Wallace Wurth Building, UNSW

BCA Assessment Report

REPORT 2010/0057 R3.1

June 2010

GFA LOWER GROUND: 2,262 m² 1 Lower Ground Floor 1:400

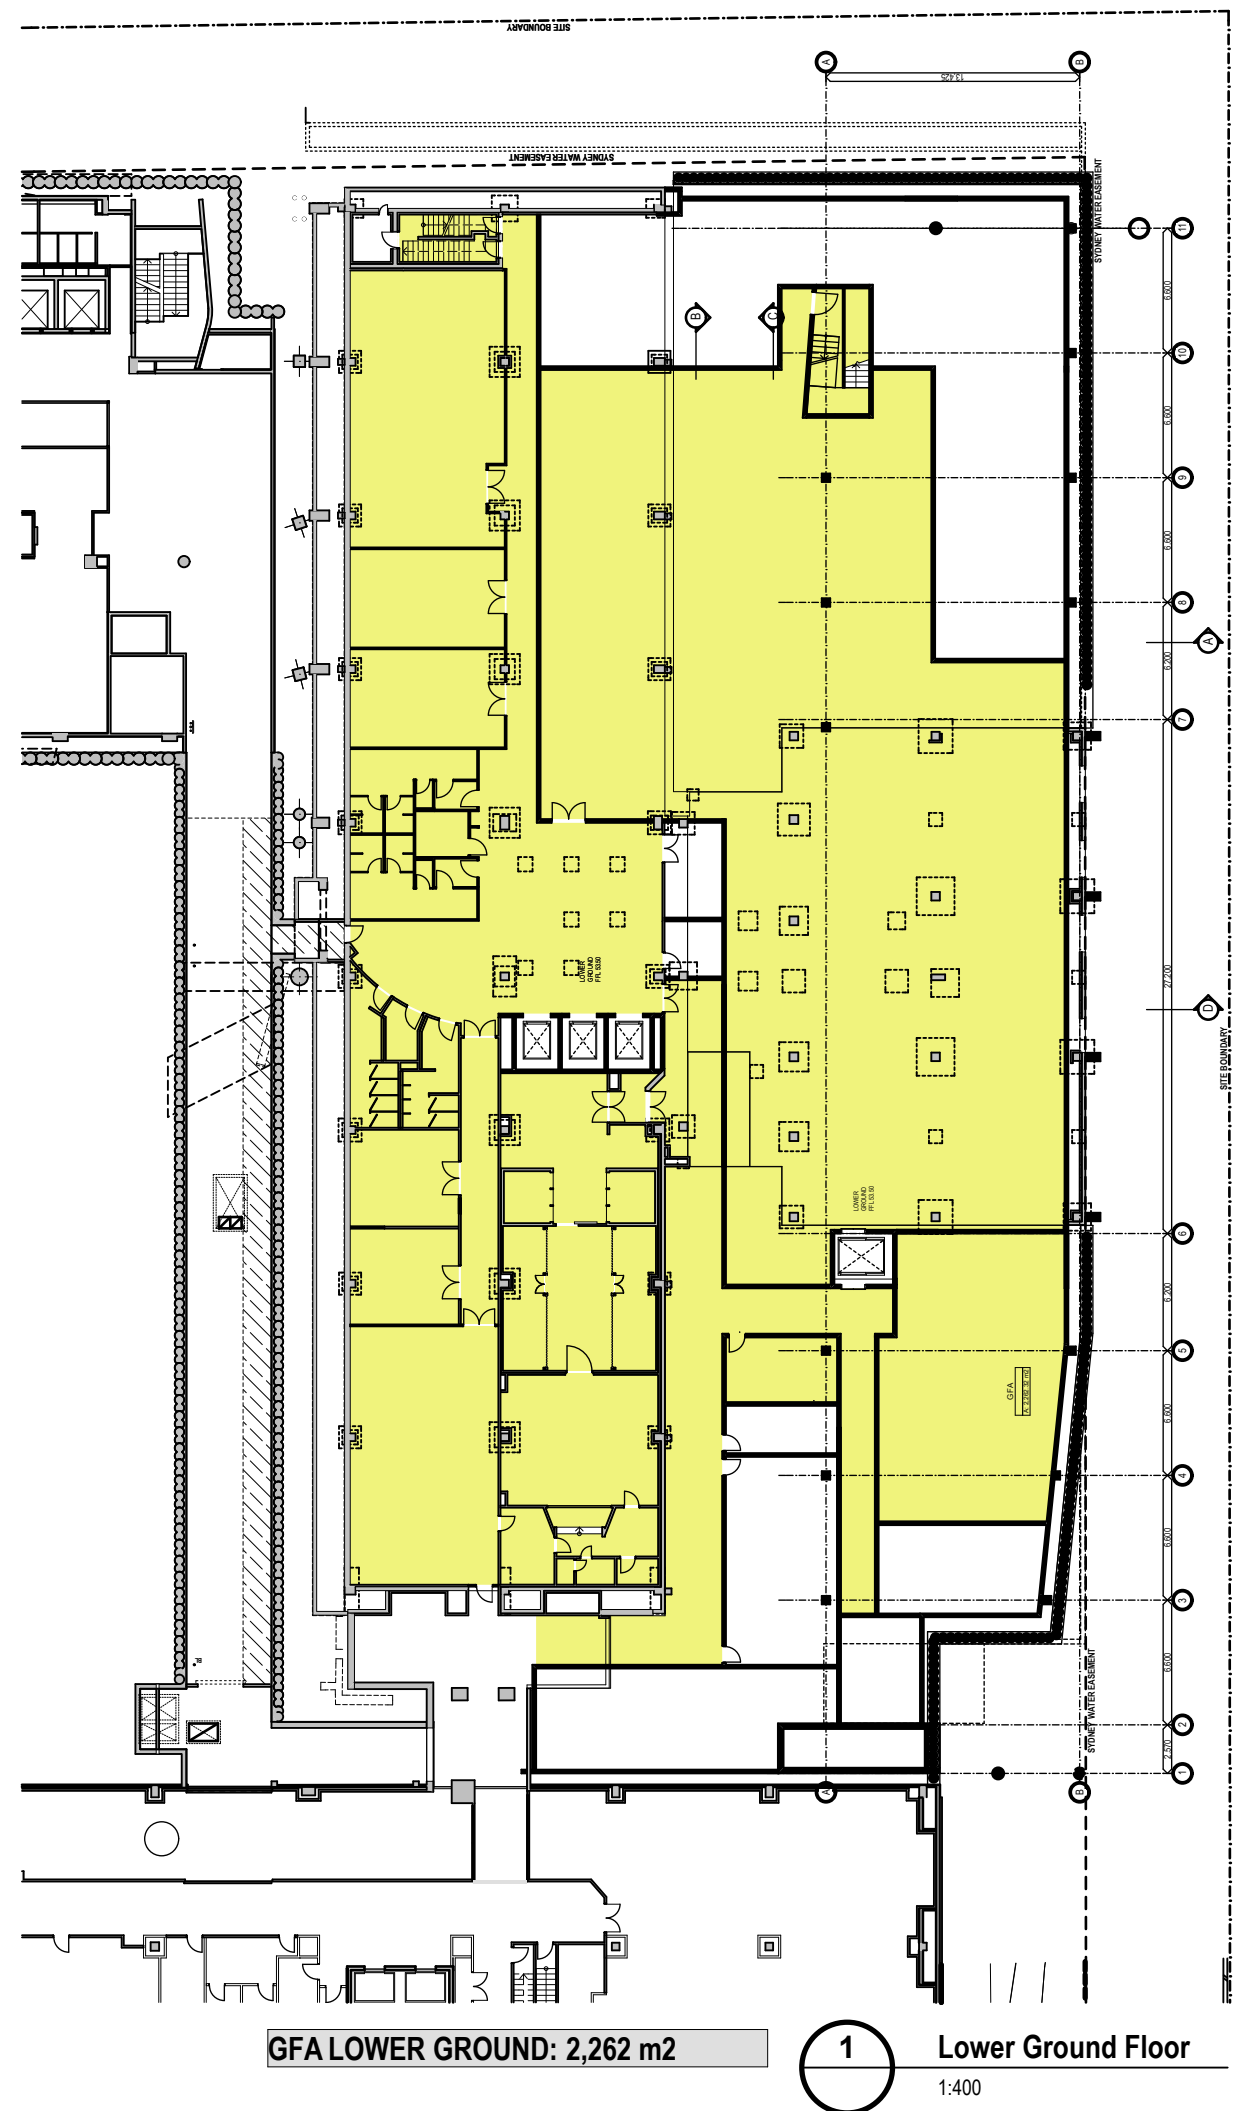
1. The proposed protection of openings as required under Clause C3.8 and D1.7 need to be specified.
2. The lower ground floor needs to be further detailed to ensure dead end travel distances do not exceed 20m and egress is provided from every room.

Item	DTS Clause	Description of Non-compliance	Requirement to Satisfy BCA
1.	D1.4	Insufficient doors are provided on the lower ground floor to ensure egress from the animal facility, morgue, BRC wash and mechanical plant room. Egress from the morgue and BRC wash may potentially have dead end travel distances exceeding 20m.	Additional doors are to be provided to ensure dead end travel distances do not exceed 20m and egress is provided from every room.

GFA LEVEL 7: 38 m² 1 Level 7 (Plant) 1:400

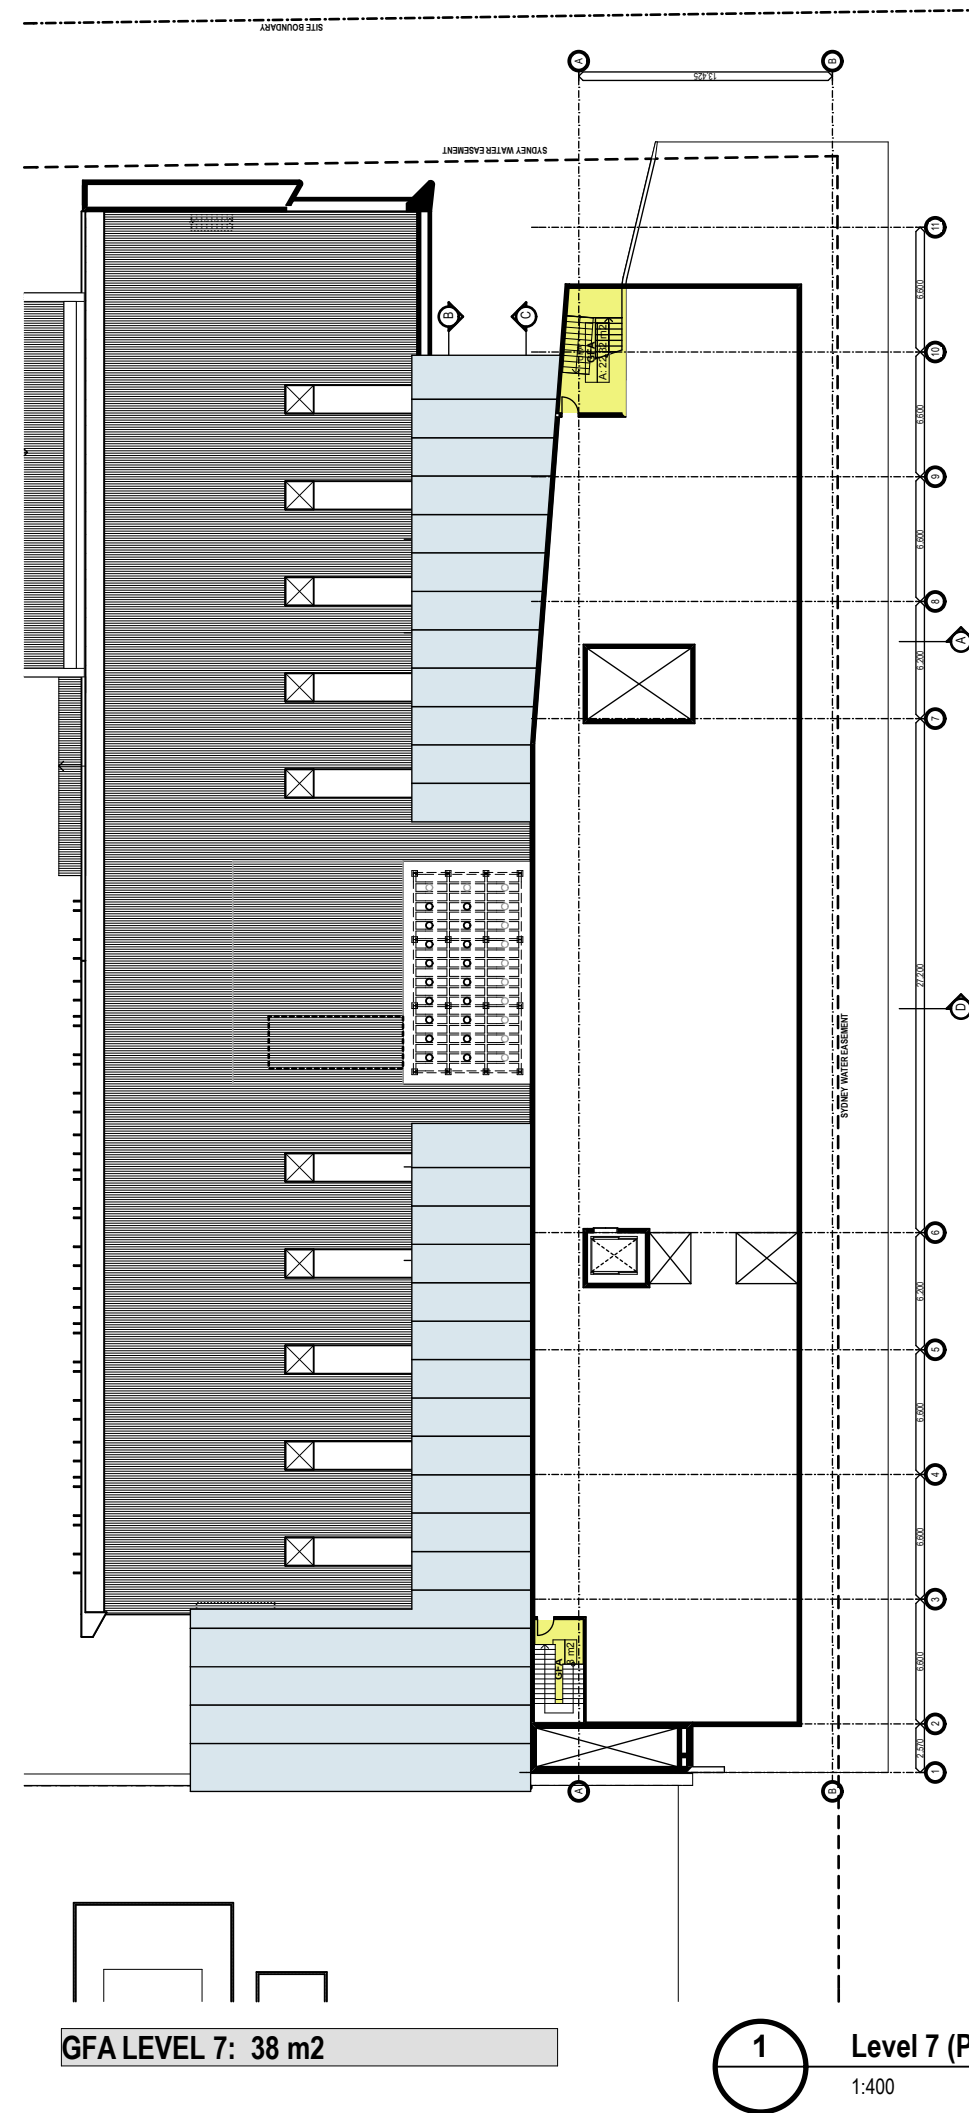
4. The door at the bottom of the southern stair serving the roof top plant room swings against the direction of egress. The doors are required to swing in the direction of egress in accordance with D2.20.

7.	Travel by non-fire-isolated stairways or ramps	D1.9	The distance from the roof top plant room via southern stair is greater than 80m and does not discharge to a point which is direct egress to a road or open space or a fire isolated passage leading to a road or open space.	DP4, DP5 and EP2.2
